**From:** Nathan Everett <Nathan.Everett@fire.nsw.gov.au>  
**Sent:** Wednesday, 29 January 2020 1:42 PM  
**To:** Olivia Hirst  
**Cc:** Fire Safety; John Hawes  
**Subject:** RE: HPRM: Oakdale West Estate Modification 2 (SSD 7348 MOD 2) (Penrith City Council) - Request for Advice

### Notice of Exhibition Oakdale West Estate Modification 2 (SSD 7348 MOD 2)

2 SECTION D - PART 2 1 : 250
WAREHOUSE - 1A

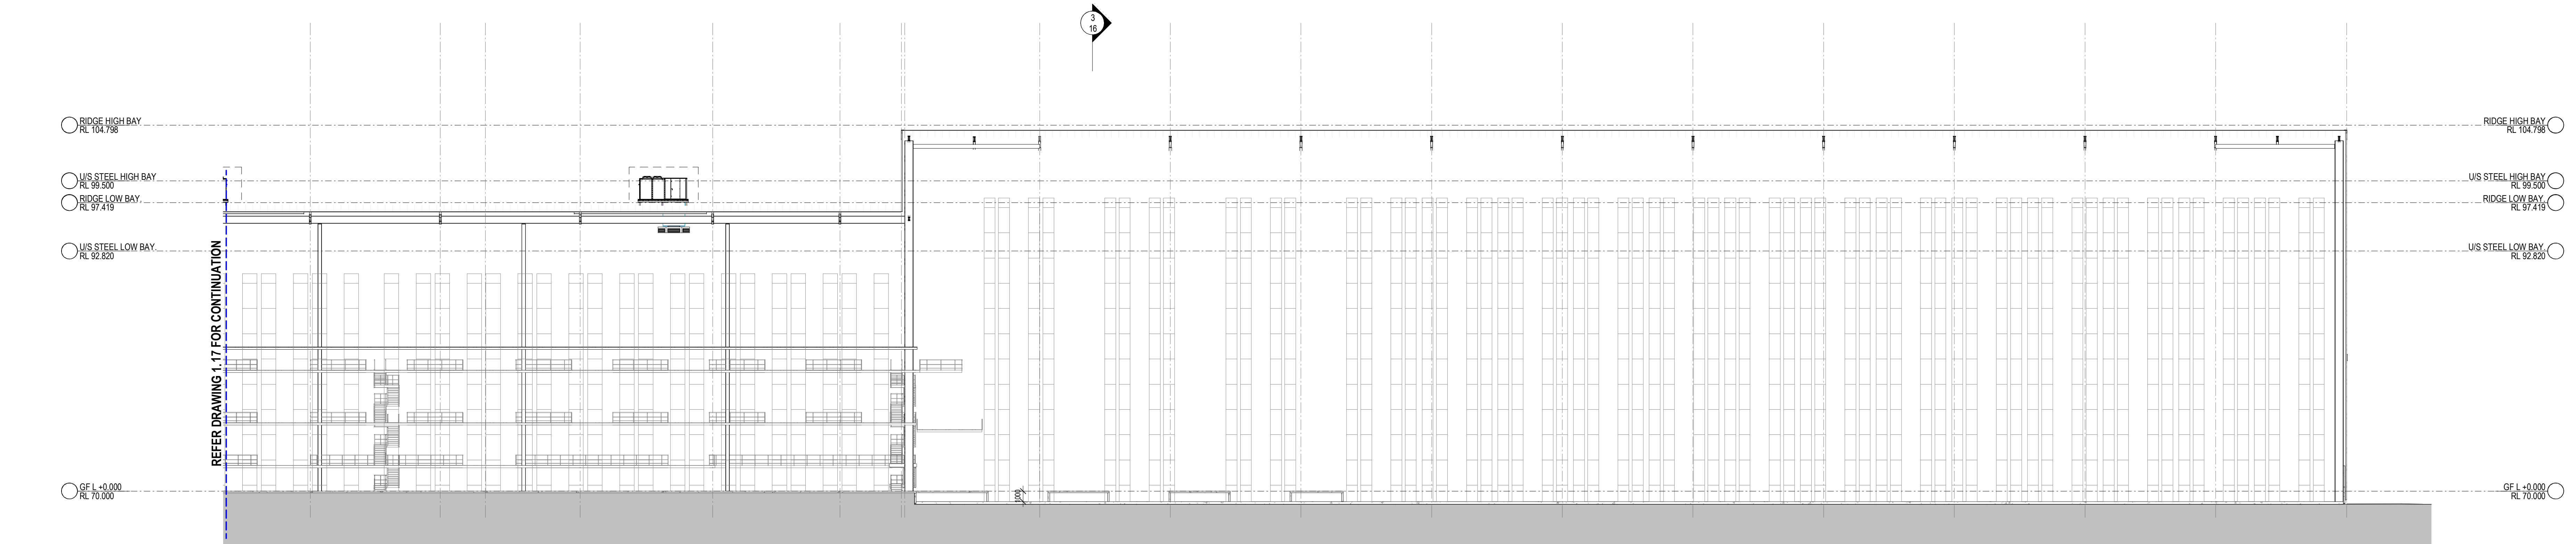
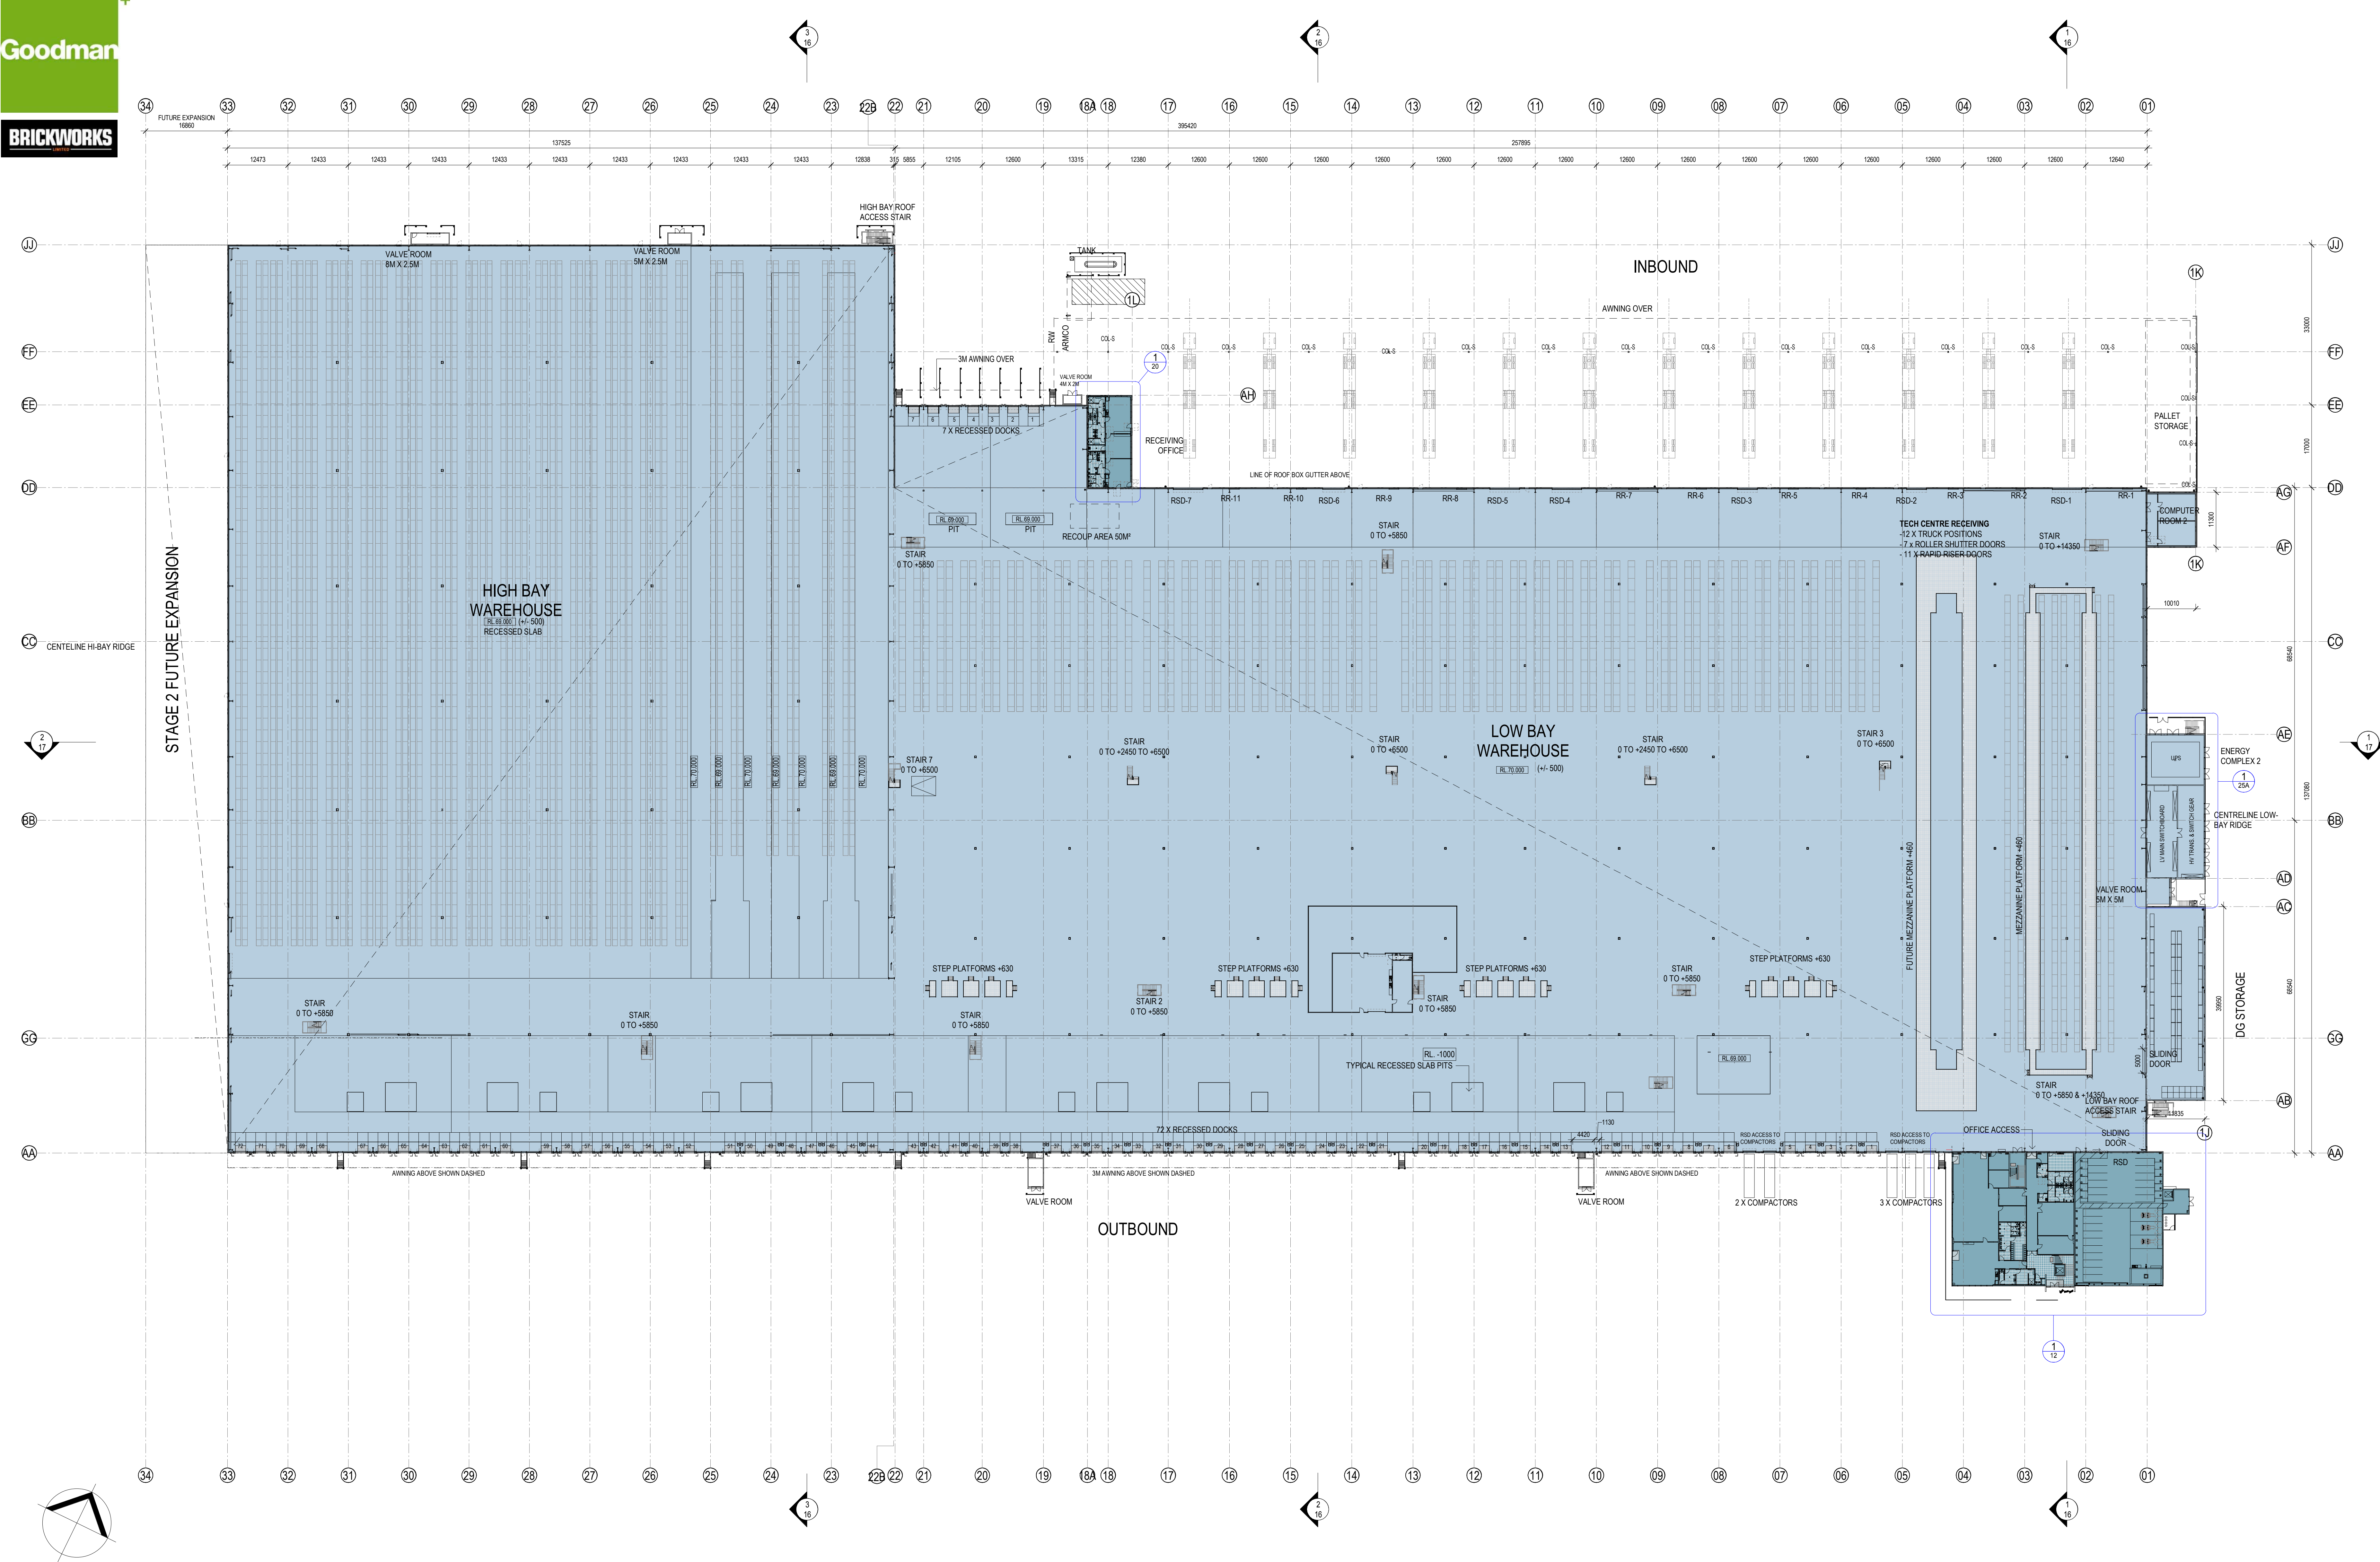
- It is noted that the modification application proposes to increase in building height for Warehouse 1A in order to accommodate automated high-bay operations. FRNSW deem that such operations constitute ‘special problems of fighting fire’ and recommend that suitable provisions be made in accordance with clauses E1.10 and E2.3 of Volume 1 of the National Construction Code.
